Martin Nugent
01254 828060
D3/12/0528

Drafted 17 October 2012

**Planning Application, Ribbles Valley District
3/12/0578 Outdoor Activity Centre, Whalley Road, Read**

drg.no. 11/26 PL 01 rev C

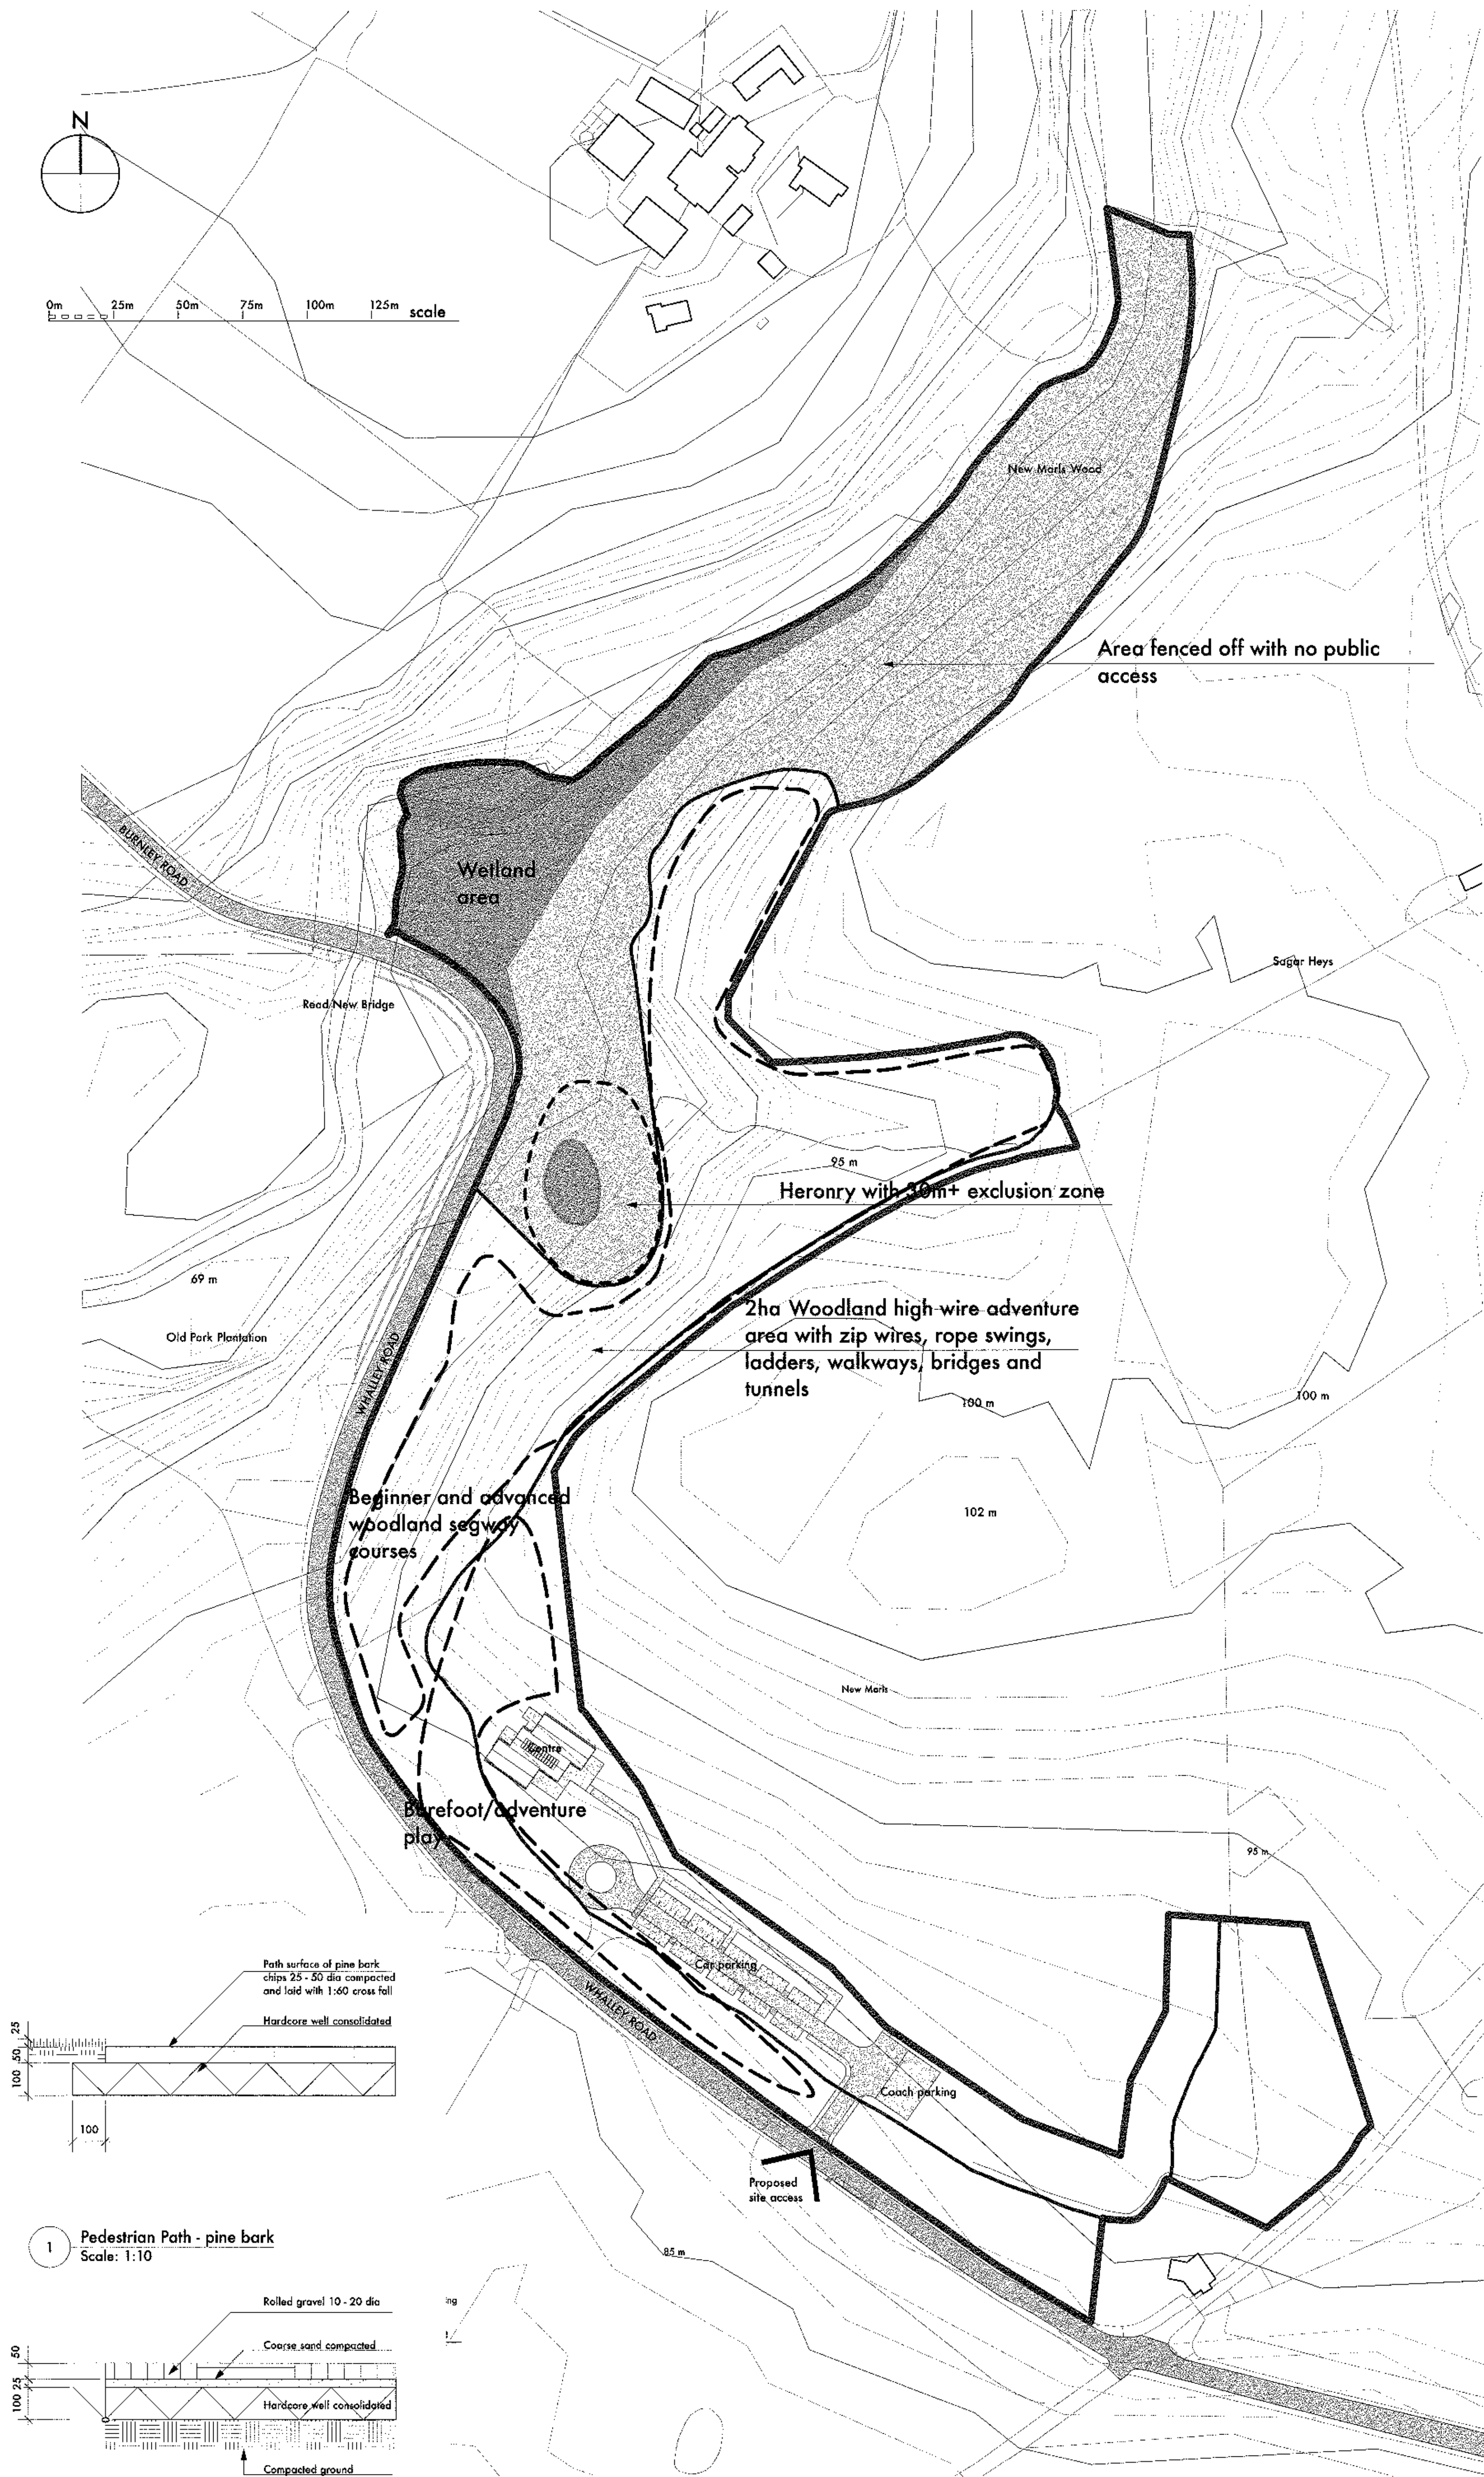
As indicated on plan, the existing field gate access to the west of the proposed access is to be permanently closed and planting reinstated. This requirement will be supplemented by a formal Highway Condition.

The site plans indicate that the main vehicular access from Whalley Road is not to be gated. I have every confidence that the site security has been considered in great detail, but would highlight that this leaves open the opportunity for the site to be accessed by unauthorised groups or individuals.

I would ask that consideration is given to omitting the rumble strip shown on the entrance to site. This will be the focus for all vehicular movements and does not serve a specific speed reduction or other safety function. Given the maintenance required on rumble strips and the proximity of on-site facilities for buses and coaches, I would recommend that this feature is removed at this location.

Drop kerbs must be provided to link the south side of Whalley Road to both sides of the main access and across this access. This will allow pedestrians to reach the site from a continuous footway link. Short lengths of new footway must also be provided to both sides of the main entrance to support pedestrian safety and to accommodate improved public transport provisions.

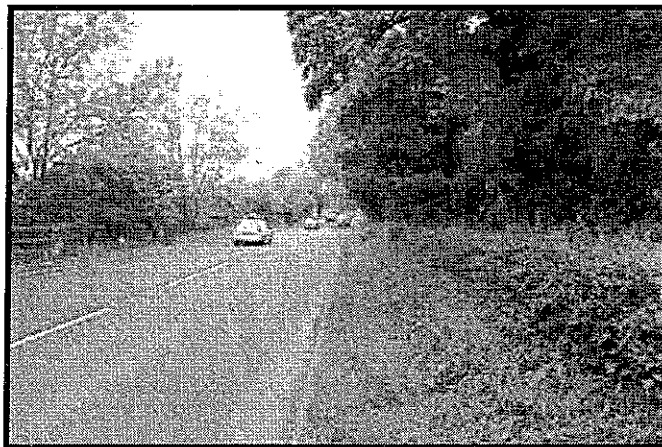
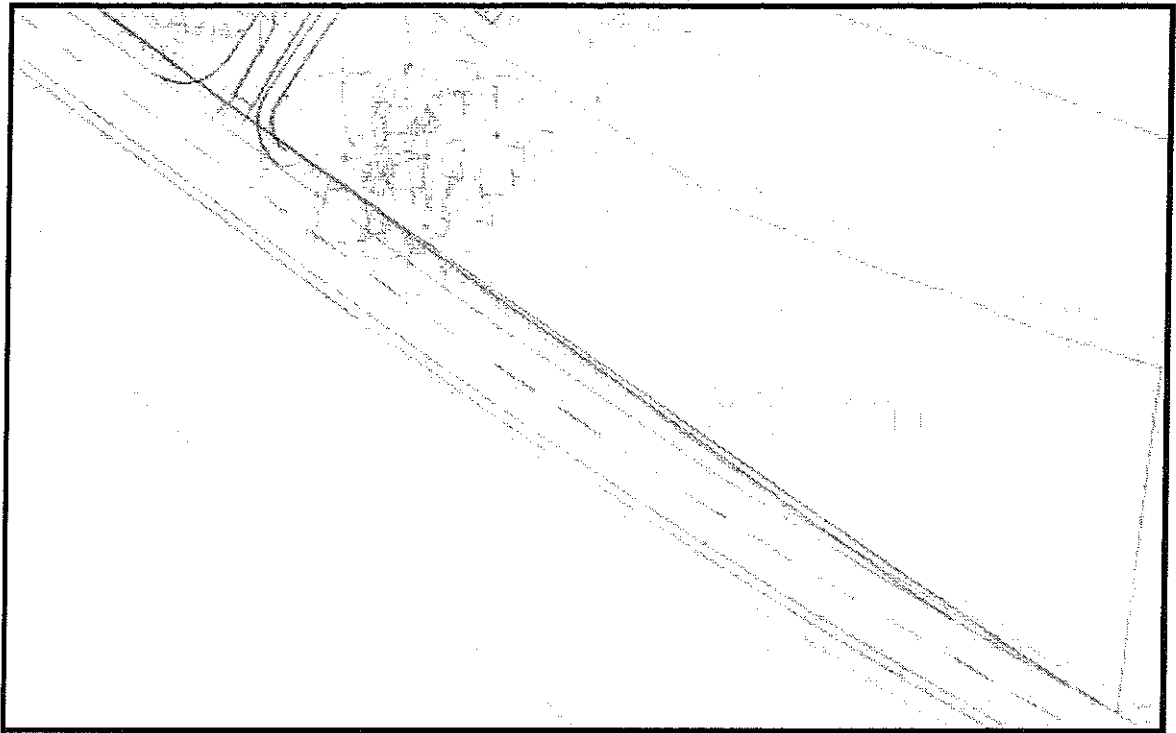
The calculation for visibility splays contained in the Transport Statement accompanying the application identify a range of 105m to 120m as being acceptable for the measured vehicle speeds on Whalley Road. I am content that this is accurate and a reasonable basis on which to proceed.

Working with the lower figure of 105m by 2.4m, the impact of construction on adjacent planting and established hedgerows is minimised. As I have no objection to the introduction of the splays achieved using this figure on this section of Whalley Road, the retention of the planting is an additional benefit.

The proposed access point does not appear to require the removal of any mature trees, but there will be requirements to raise the crown on some specific trees and to alter the line of hedgerows that fall within the visibility splay.
